From: Elkhorn Estates <info@elkhornestates.org>
Sent: Thursday, March 23, 2023 3:45 PM
To: PCD Hearings
Cc: Steve Kinder; gregmartin9460@gmail.com; krisgee69
Subject: Elkhorn Estates HOA Input - SKP 231
Attachments: Elkhorn Estates HOA Response to SKP 231.pdf

The Elkhorn Estates HOA Board of Directors reviewed the recently posted Sketch Plan (SKP 231) for Autumn Hills (aka Autumn Acres). Our members will be directly and indirectly impacted by the proposed development, so we prepared the attached inputs for consideration by the Planning Commission and Board of County Commissioners when they respectively hear the application. We'd be grateful if you would acknowledge receipt of the inputs, and include them in those bodies' hearing packets as appropriate.

Homes within the Elkhorn Estates Homeowners' Association border the proposed Autumn Hills development, and on behalf of our members, the HOA Board of Directors offers some related comments and concerns for consideration by PCD, the Planning Commission, and the Board of County Commissioners. Concerns include insufficient density transitions, insufficient water commitments, an ill-advised and flawed traffic study, and some internal i

Figure 11

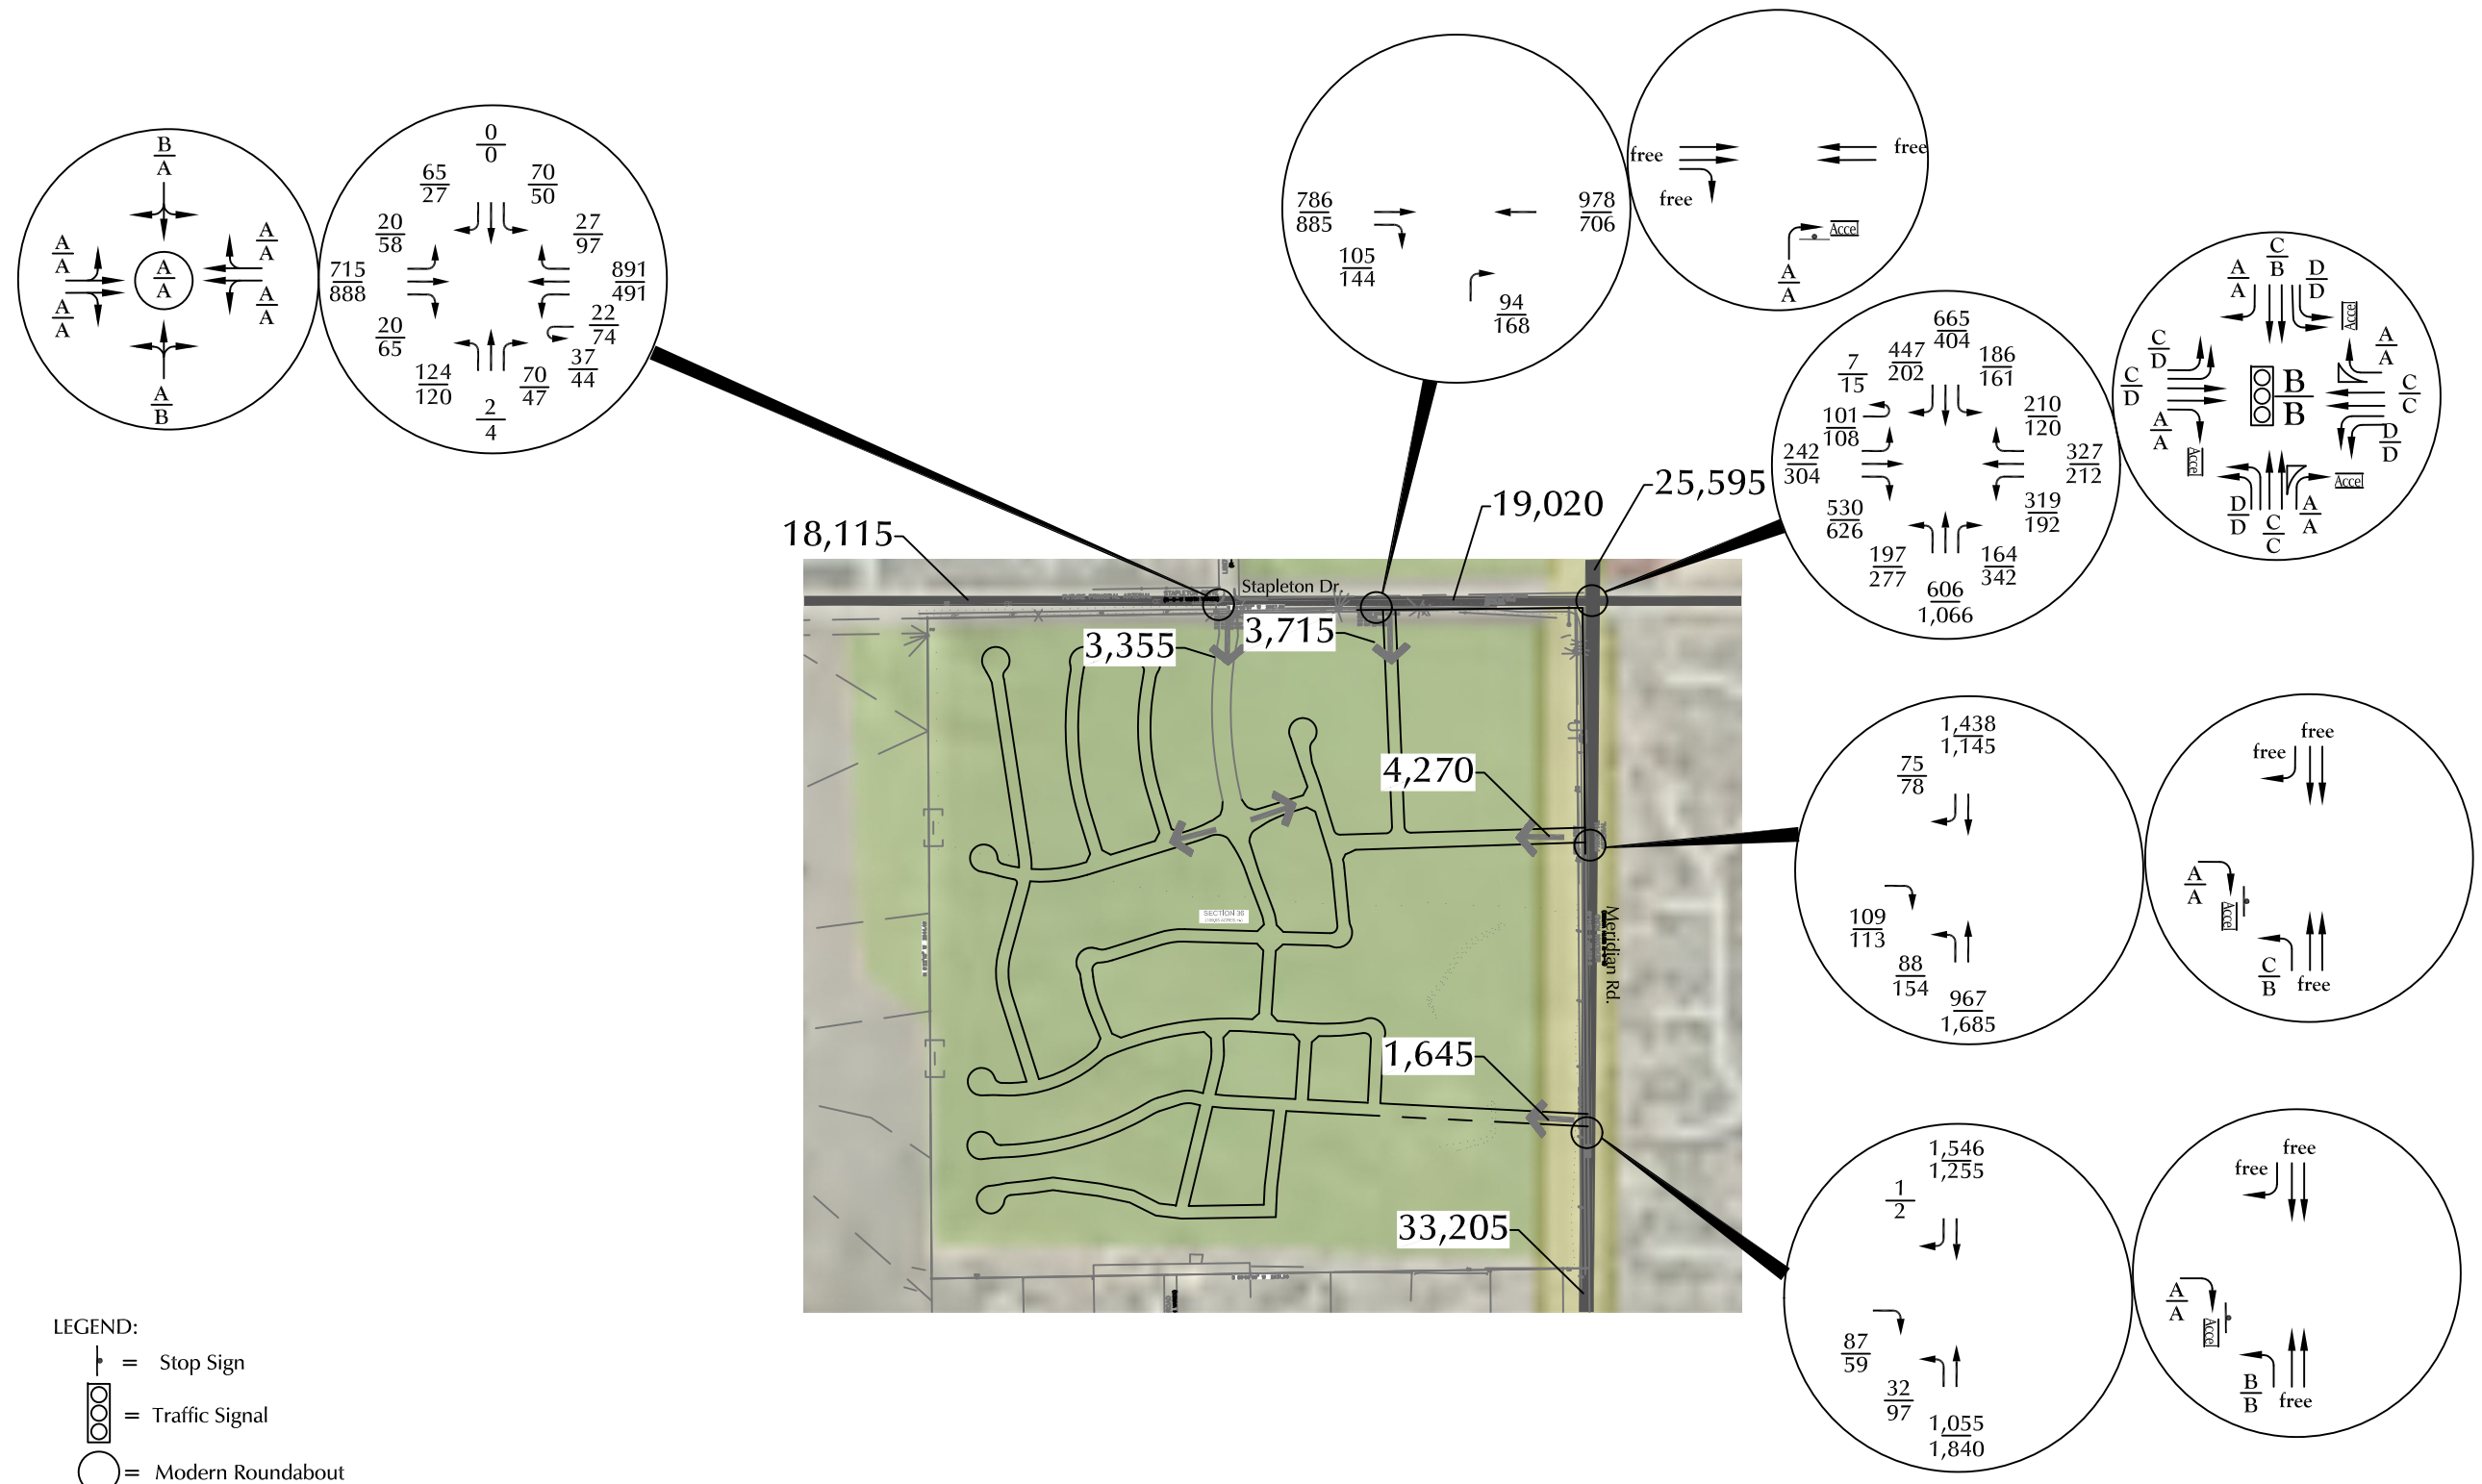
earlier one produced by the same consultant for "The Ranch". Specifically, LSC #184390 produced for "The Ranch" shows projects 2040 total traffic at the Meridian / Stapleton intersection as 35,765 vehicles; the Autumn Hills study (LSC #S224050) shows total 2042 traffic as only 25,595 vehicles. The bottom line is that the traffic issues need more scrutiny, especially with respect to the actual traffic levels and to the advisability of the principal arterial deviations.

ZONING MAP

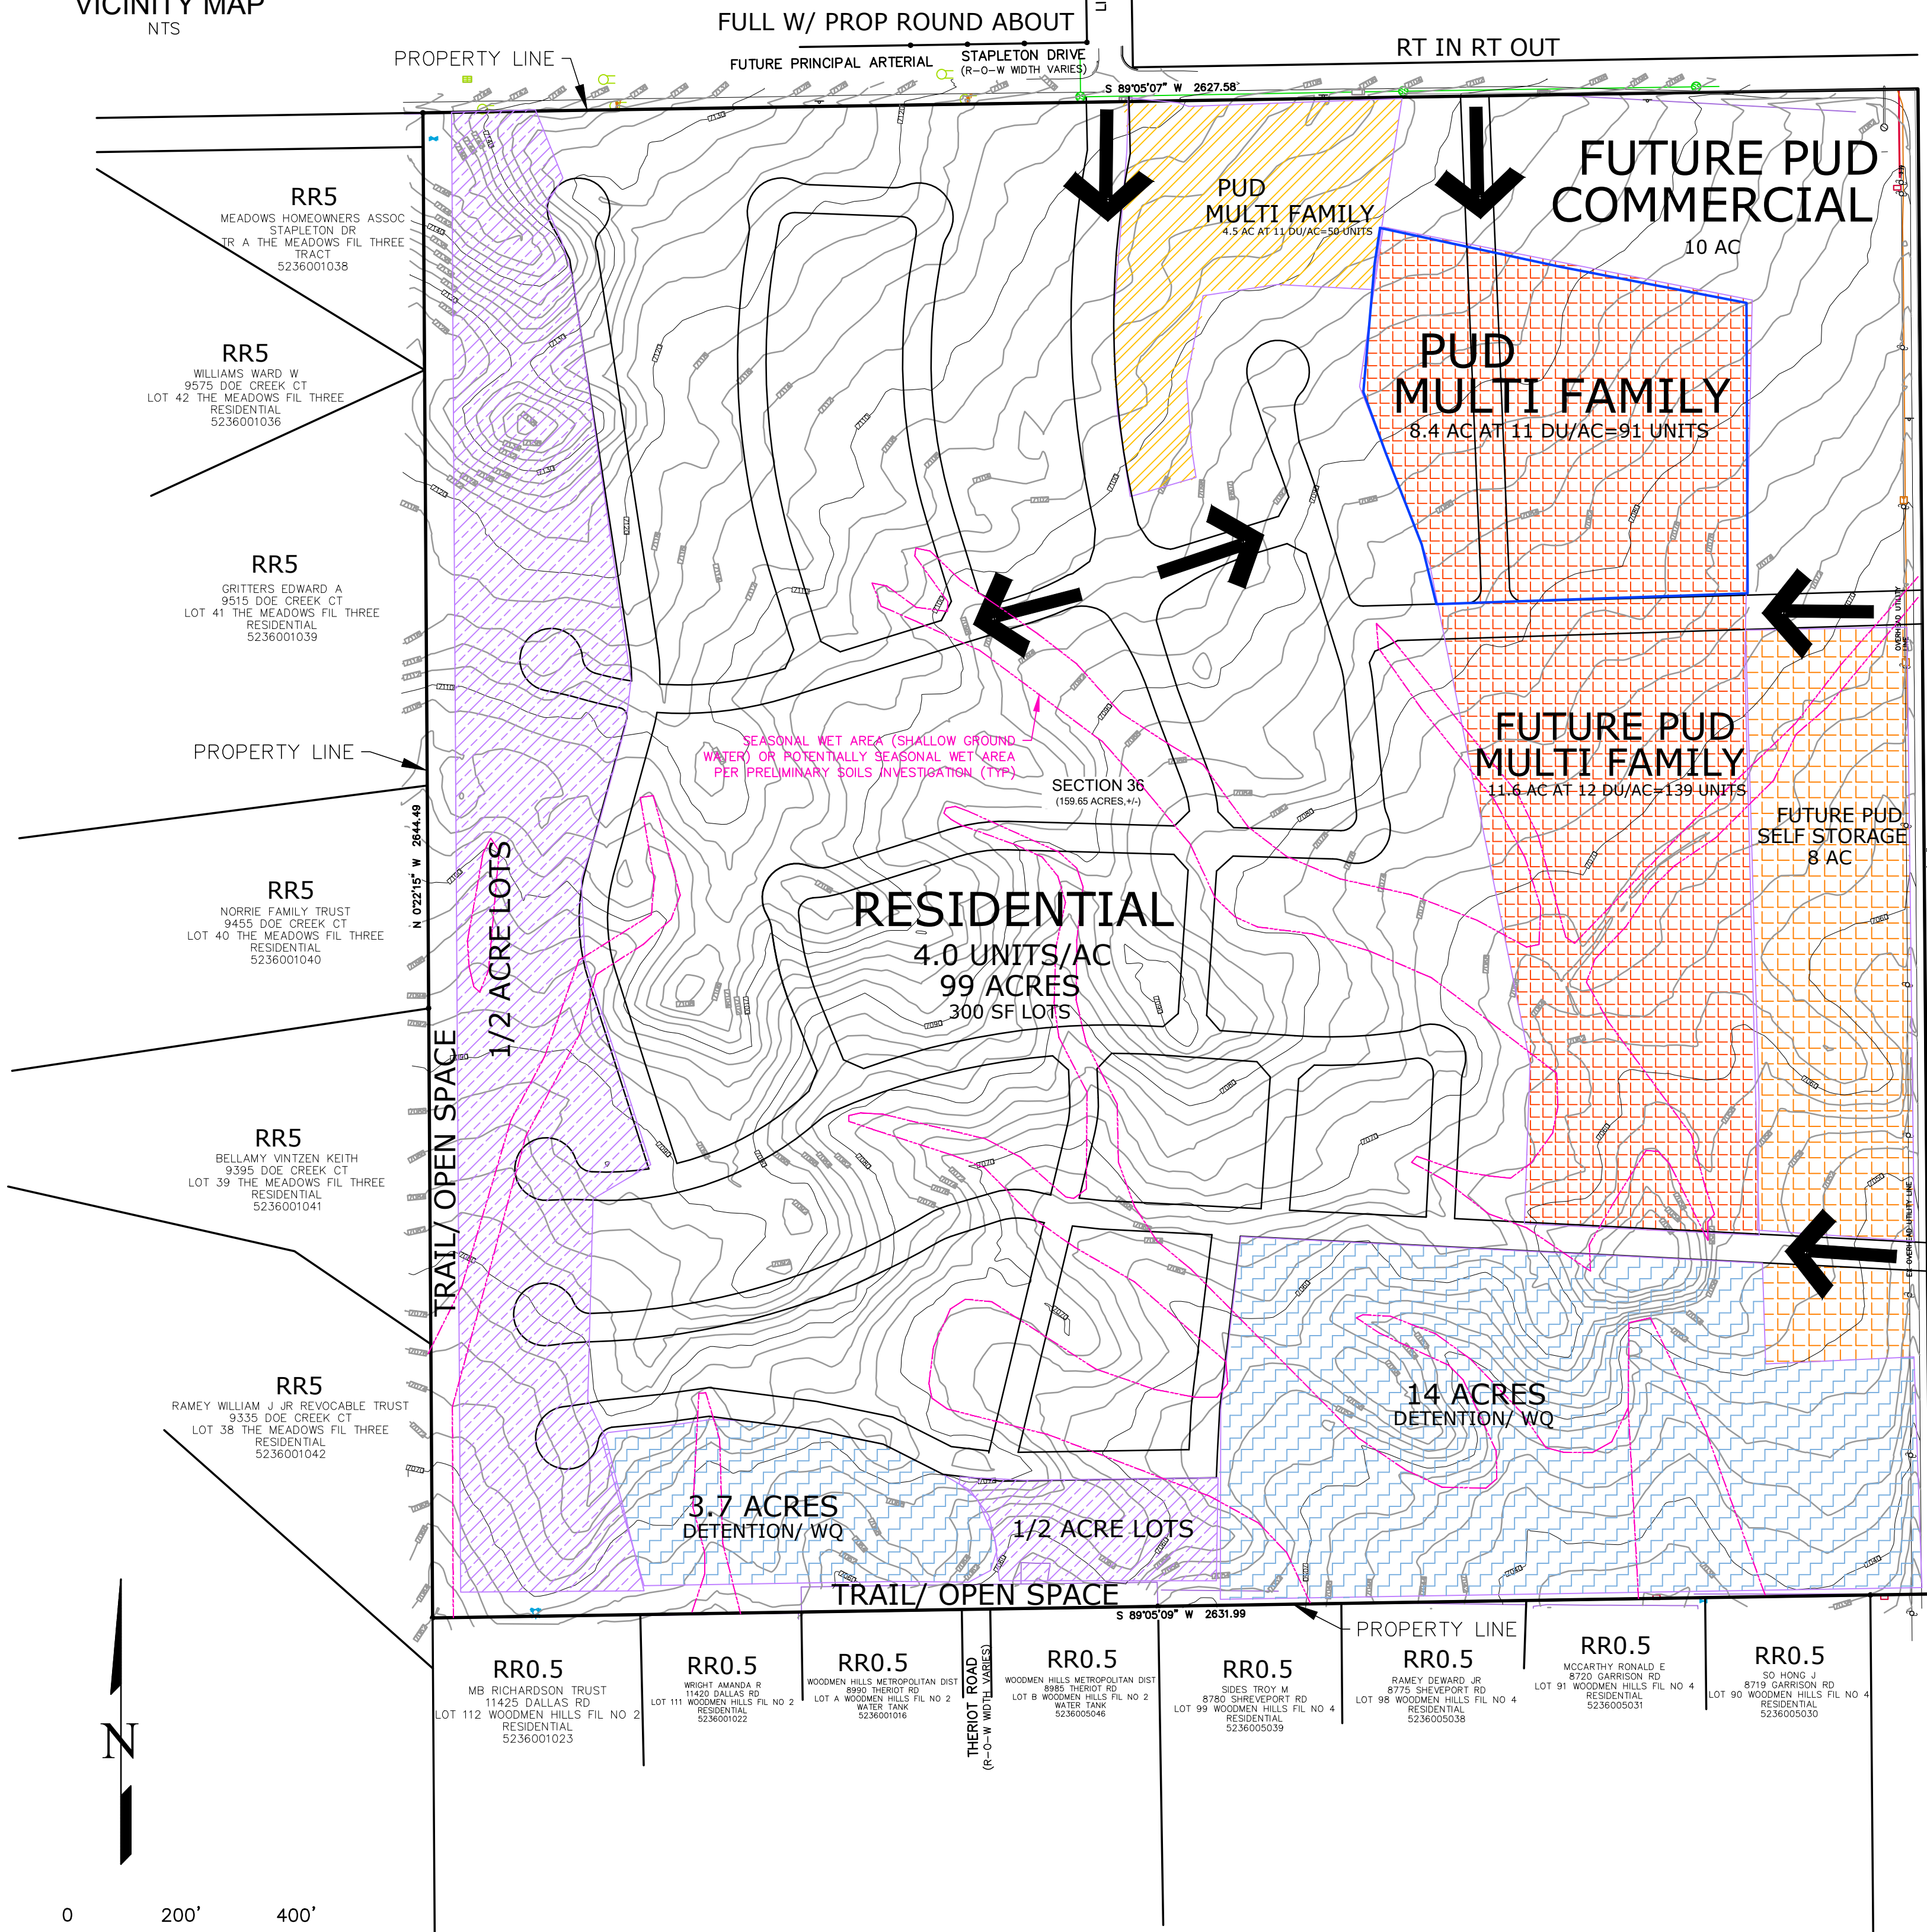
1) Insufficient Density Transitions. This is without a doubt our most significant concern. Responsible development respects the rights of both the developer and neighboring home owners. The ½ acre lots along the west boundary of the proposed Autumn Hills development abut the 5 acre properties in Elkhorn Estates, with a 50 foot open space. ½ acre lots are significantly too small to provide a responsible density transition and a mere 50 feet open space is significantly too narrow to be effective as a buffer to make up the difference. As we communicated to the developers prior to the SKP filing, we suggest that Increasing the size of the lots on the western border to 2.5 acres would provide a more reasonable density transition and respect the rights of the neighboring homeowners while having only a minimal impact on the number of homes proposed for the development (approximately 12 fewer homes total).

4) Sketch Plan is Internally Inconsistent. The Letter of Intent (pg 2) states in part, "*As Meridian Road is a principal arterial, fronting it with residential land is not desirable.*" Yet the Sketch Plan depicts residential land on the north boundary fronting Stapleton Drive, which is scheduled to be a Principal Arterial. Why is it a bad idea for Meridian but a good idea for Stapleton?
